30th May 2023

Your Ref: 23/01316/F

Erection of 5 two storey age restricted dwellings (55 years) for older people with access, landscaping and associated infrastructure - Land South of Faraday House, Woodway Road, Sibford Ferris (Application No. 23/01316/F)

Sibford Ferris
 OX15 5QW
 Plot 02
 Elevations

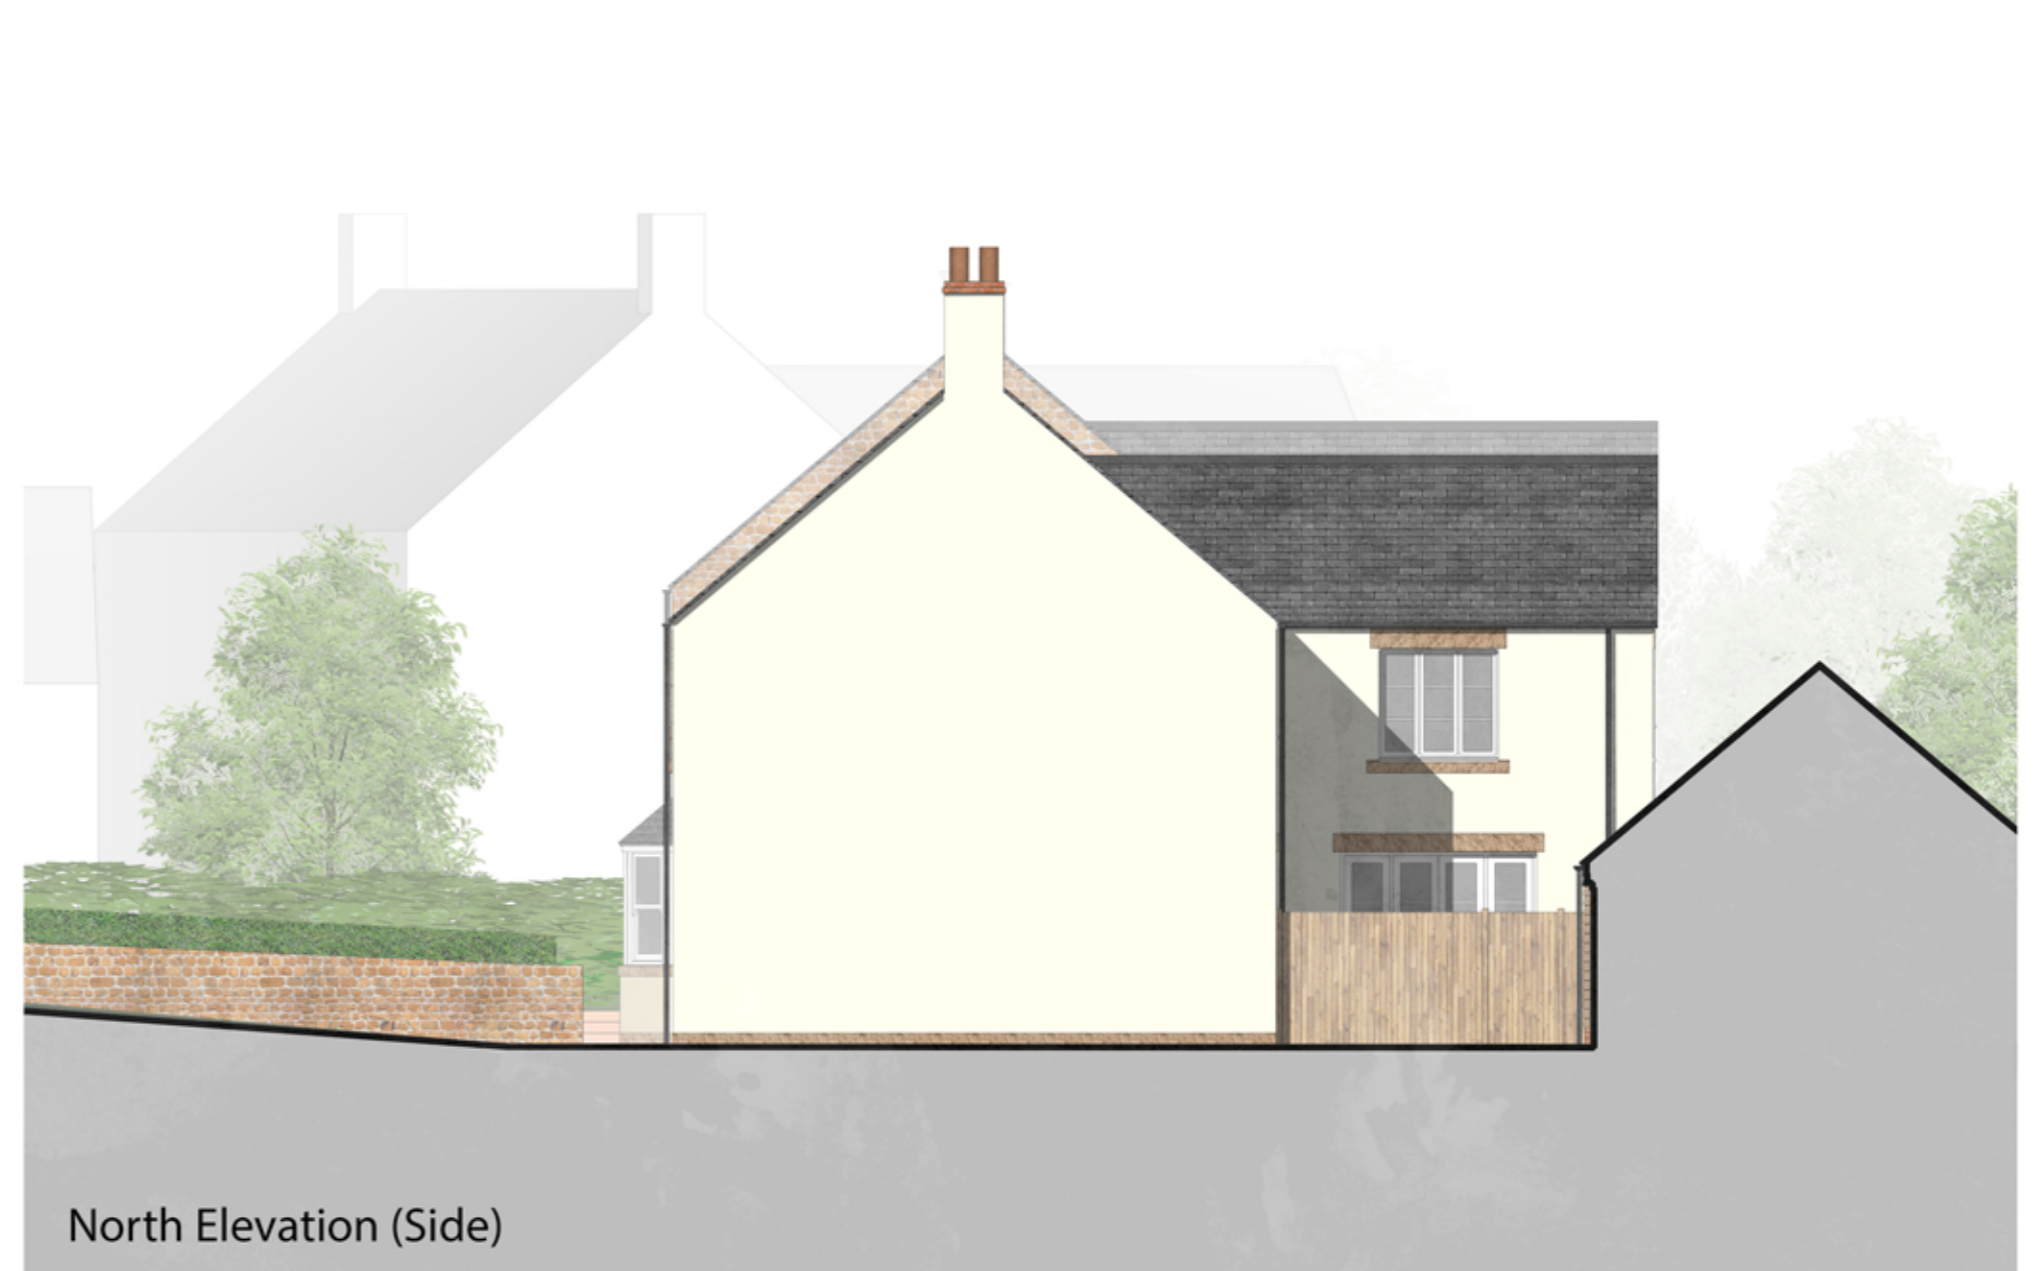
The physical impact of the dwellings – especially Plot 5 – is perhaps most acute upon Faraday House just 15 metres to the north of the site, as shown on Figure 6 taken from the application.

Figure 6 – View of Proposal from the North (Faraday House)
